Planning Inspectorate

Application by Springwell Energyfarm Limited for an Order Granting Development Consent for the Springwell Solar Farm

Issue Specific Hearing 3

Action Points:

EN010149/APP/6.2.4

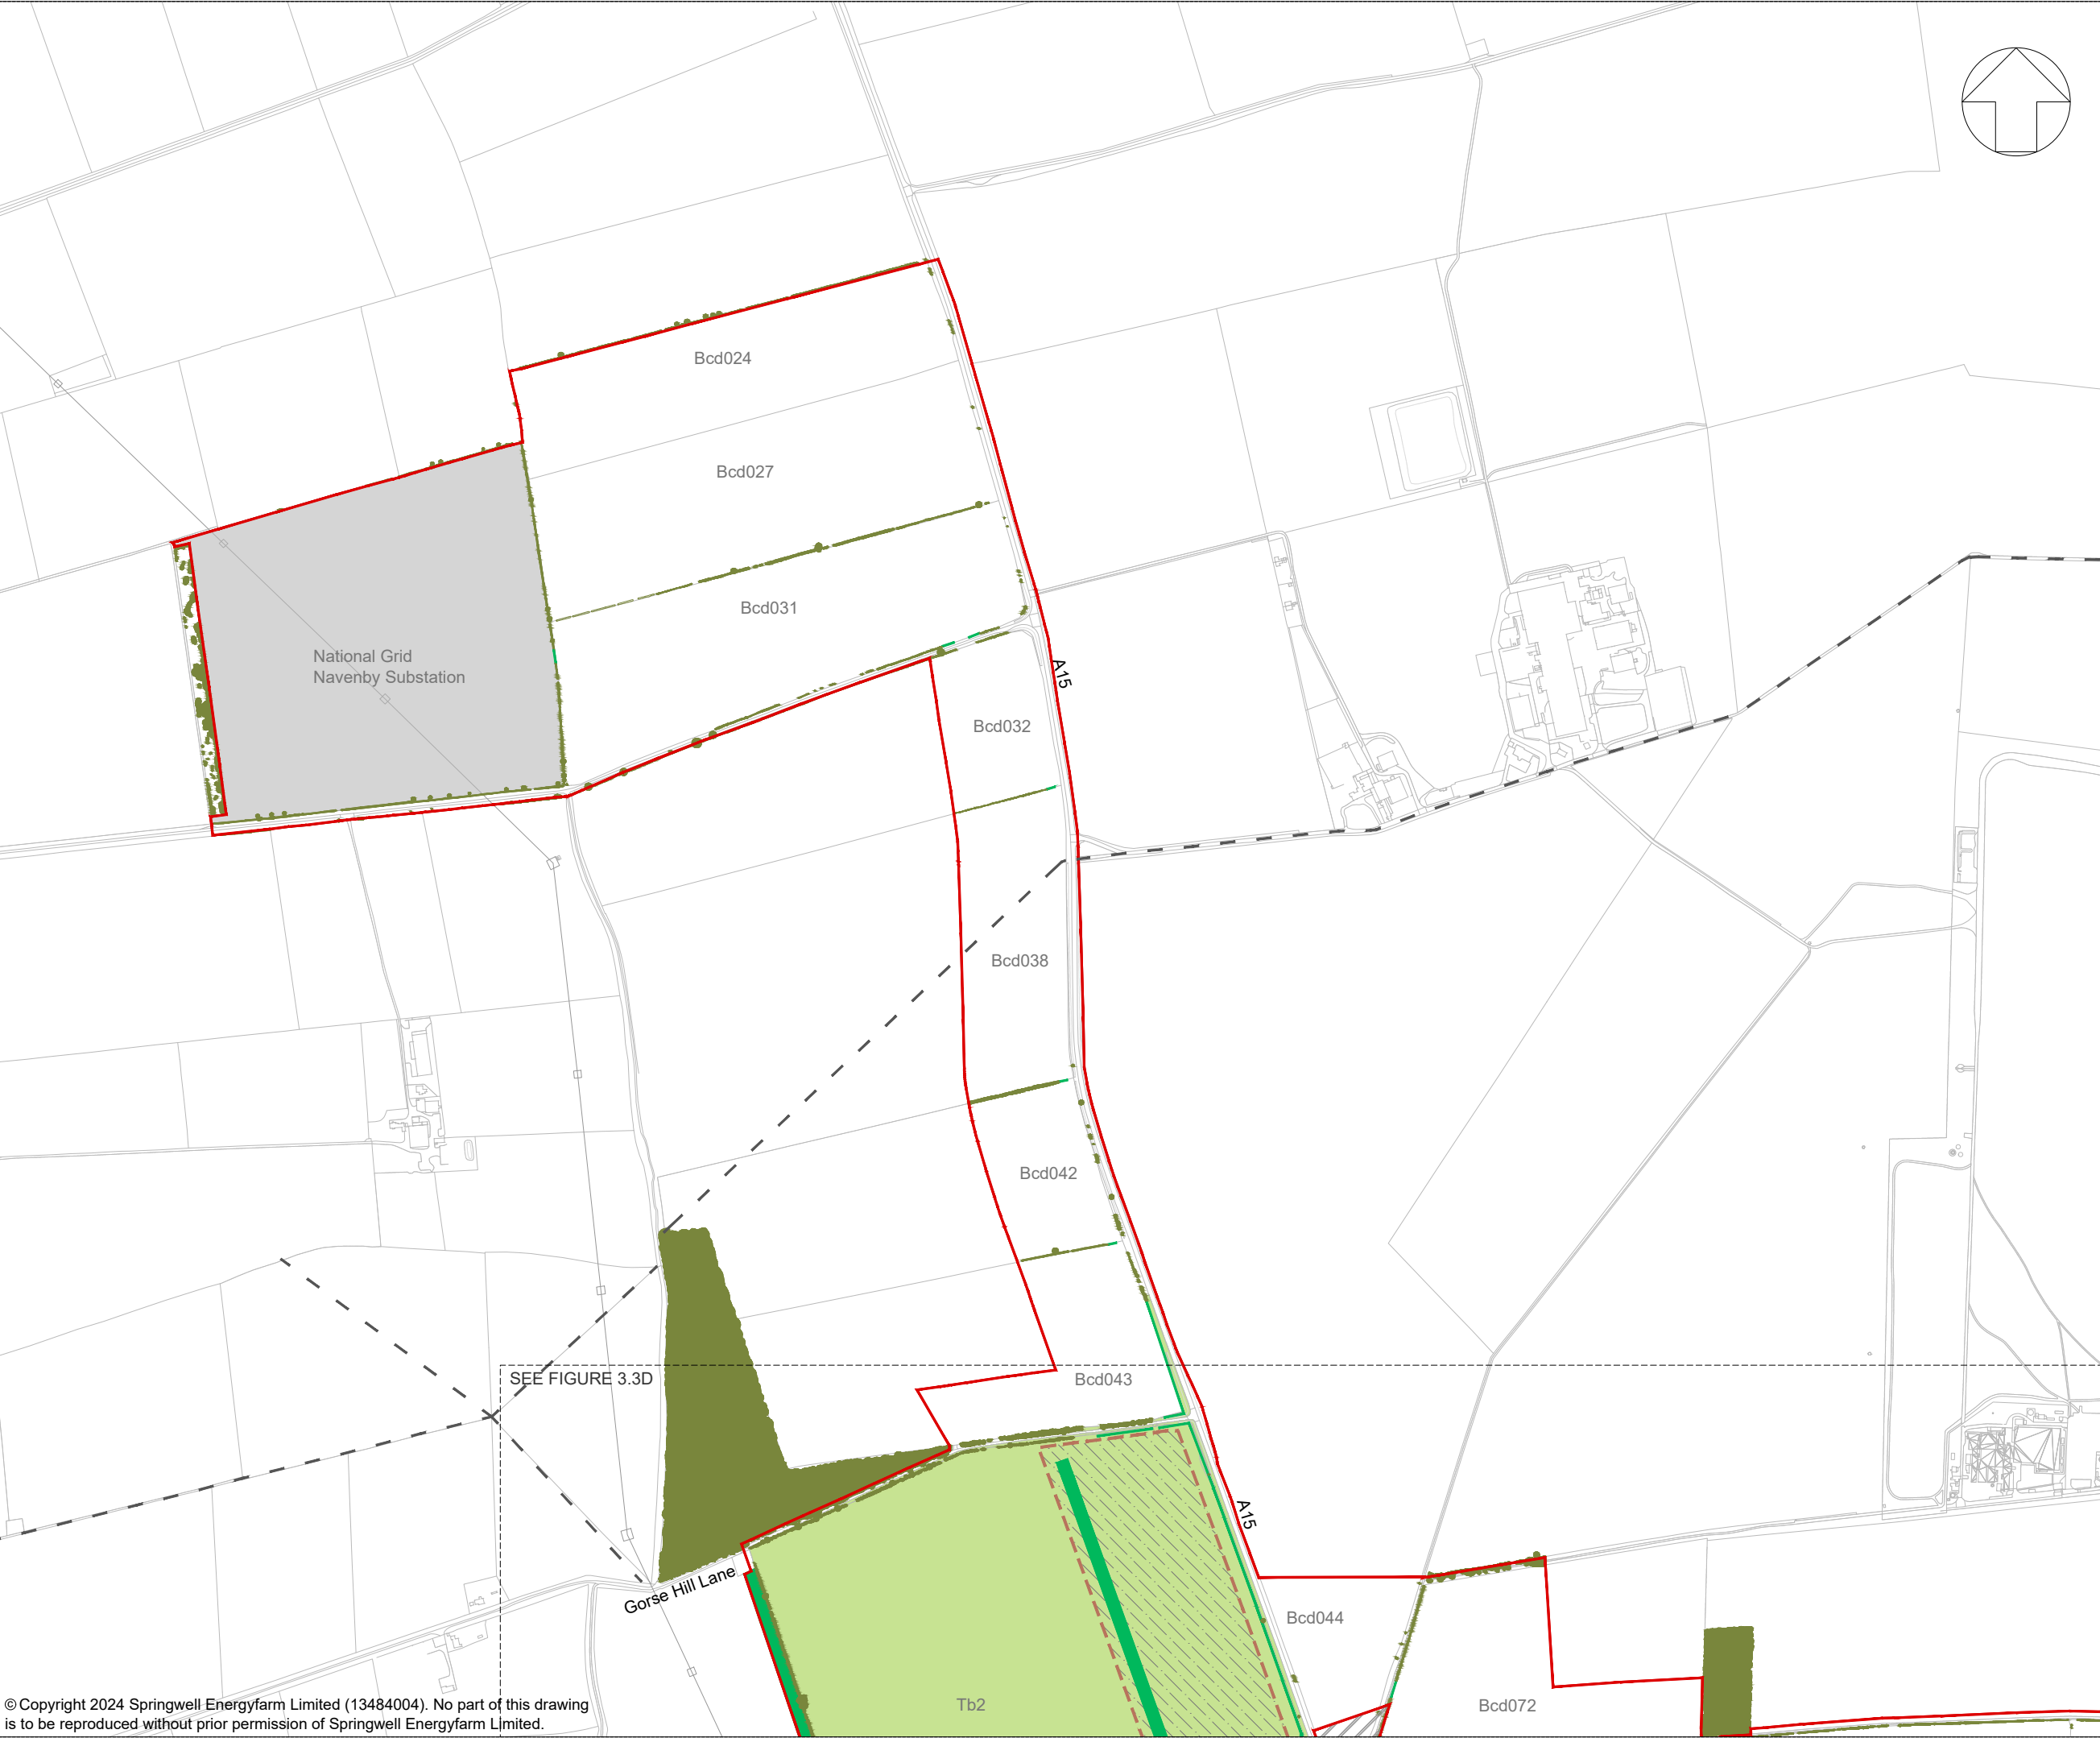
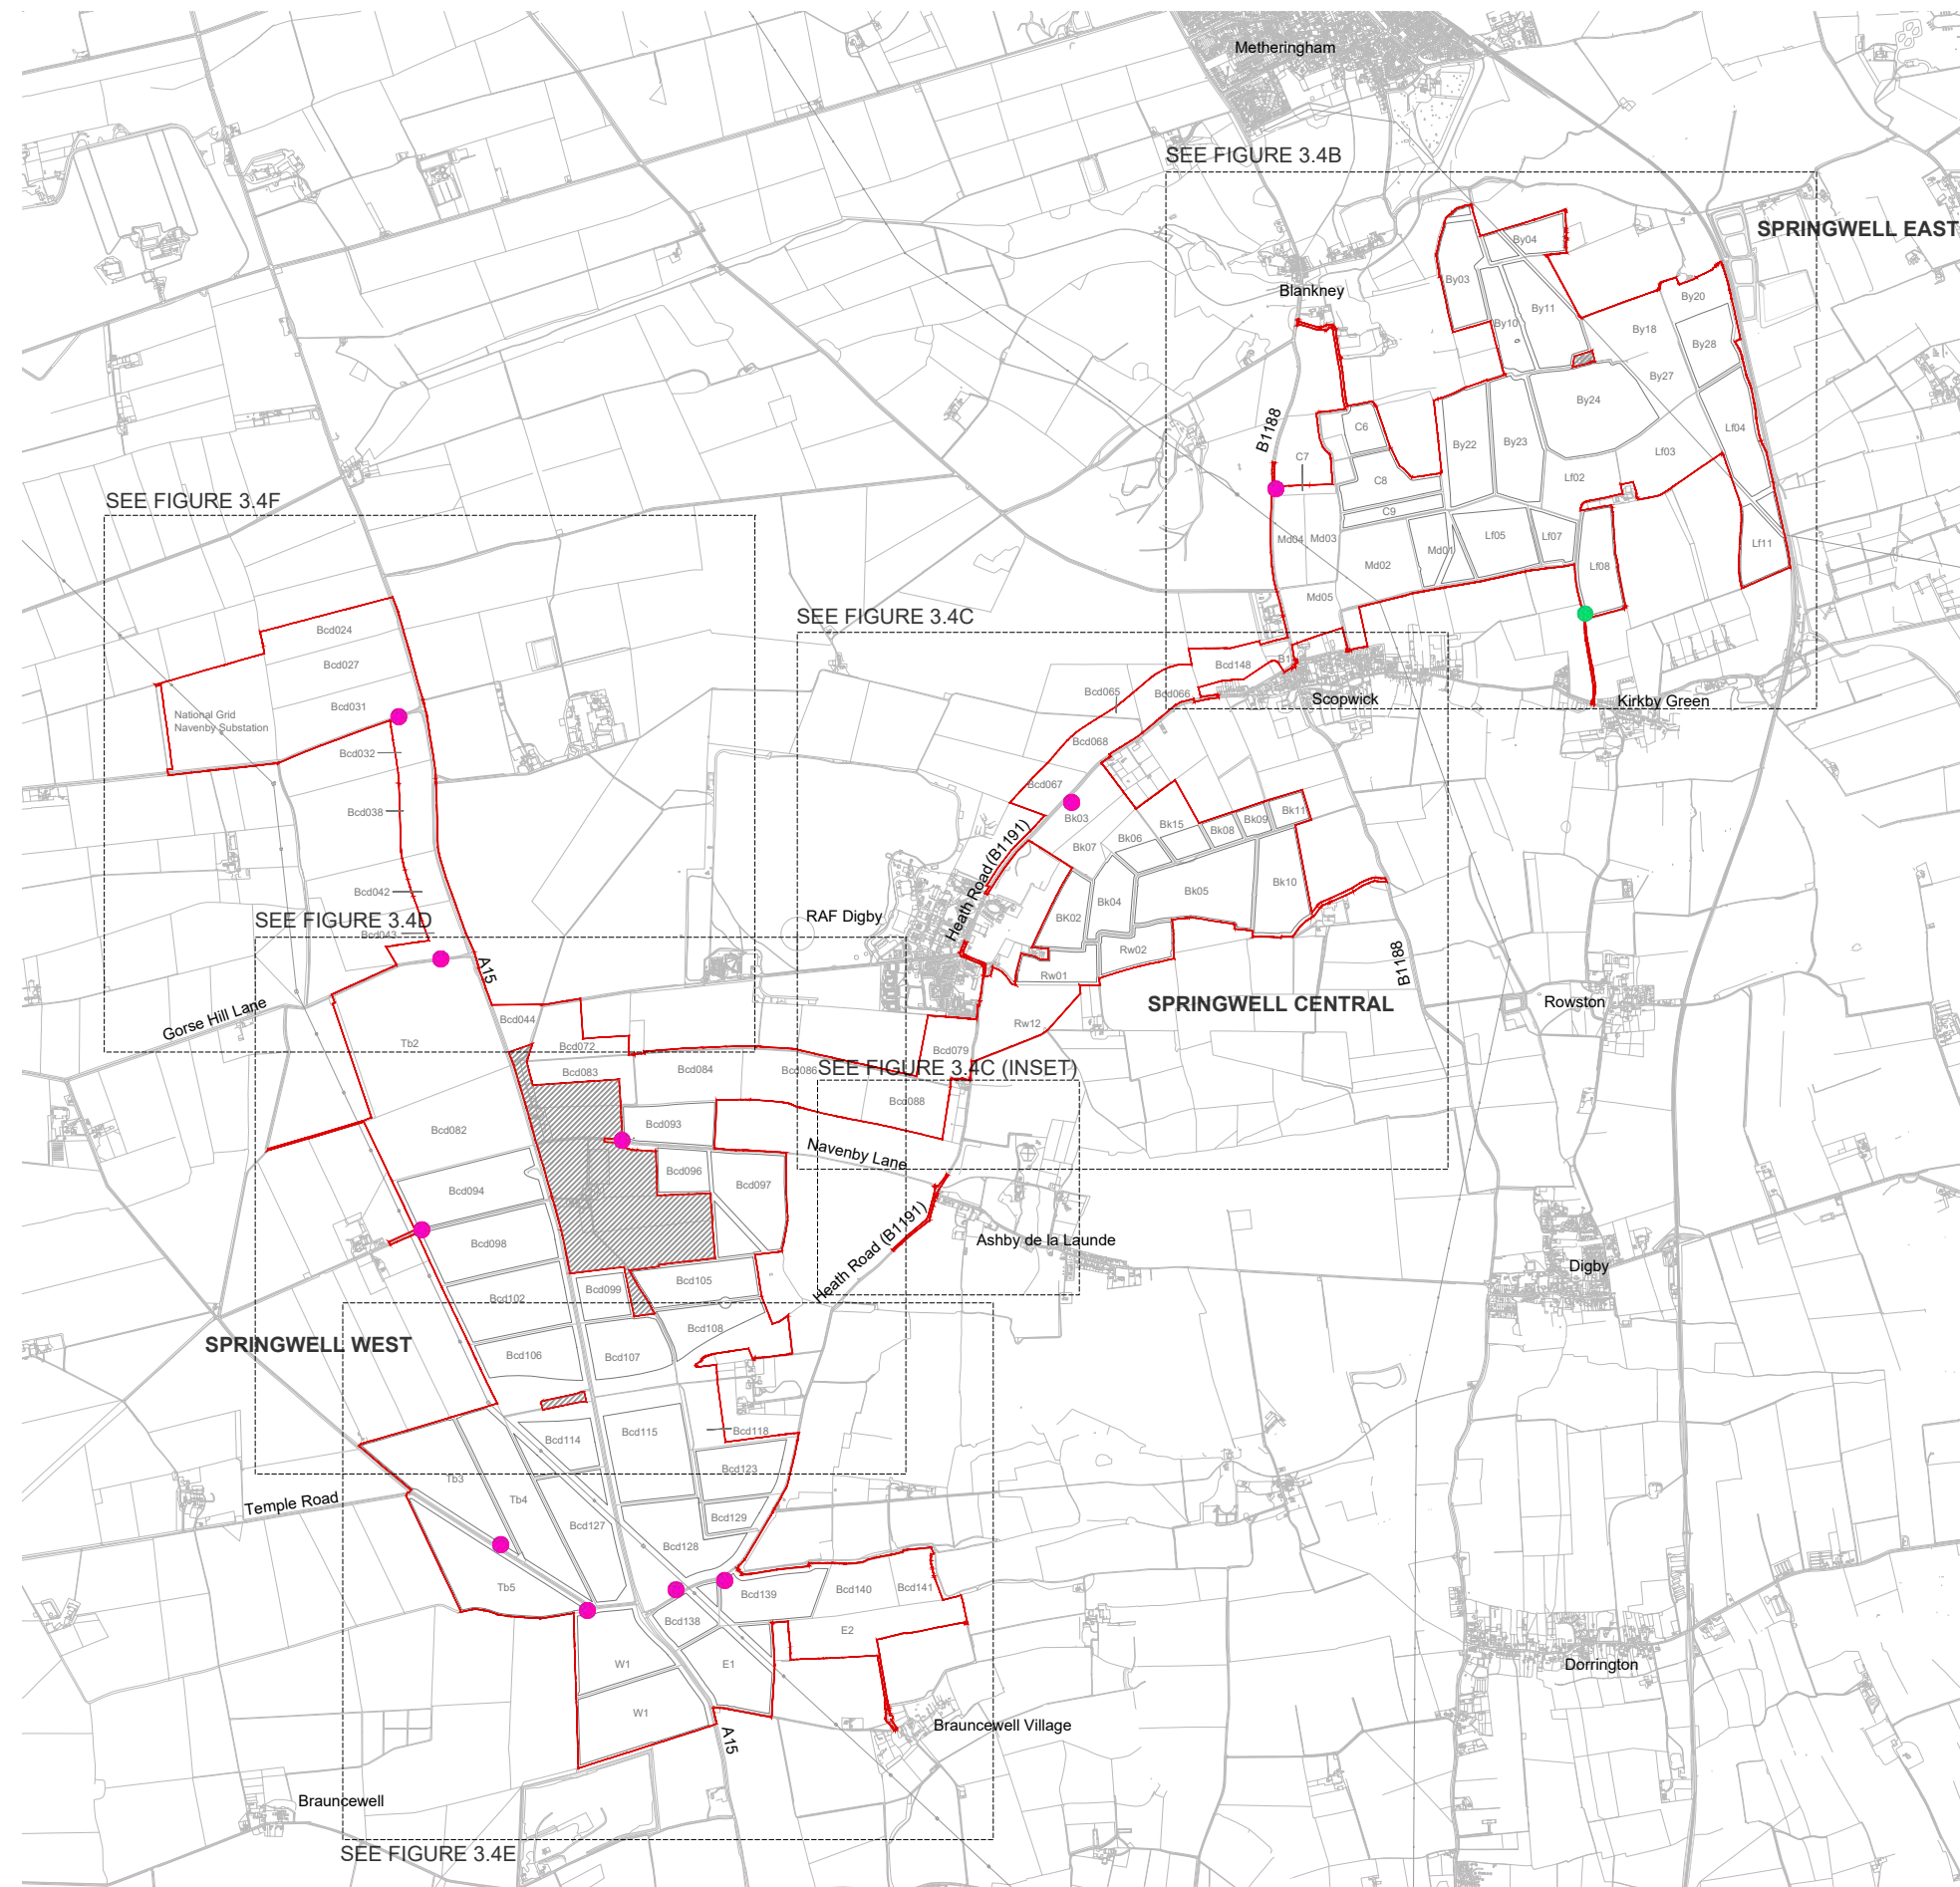
No.	Party	Action	Deadline
		'sealed over' land has been considered as a permanent impact.	
10	Applicant / EA	To have further discussions on wording relating to unexpected contamination	D3
11	Applicant	Scarce Arable Flora - Confirm whether the green infrastructure margins in field Bcd115 shown on the green infrastructure BNG parameters should extend to the north-east corner of the field to include target note location 9 and also whether the proposed strategic tree belt clashes with target note location 10.	D3
12	Applicant	Provide map showing location of proposed mitigation works for ground nesting birds.	D3
13	Applicant	Provide revised dDCO including anticipated BNG figures in Requirement 8.	D3
14	Applicant / NKDC	Further discussions to take place in relation to the data used to assess tourism effects and monitoring measures that could be put in place to understand the impact on tourism related to the use of PRow and stepping out network.	D3
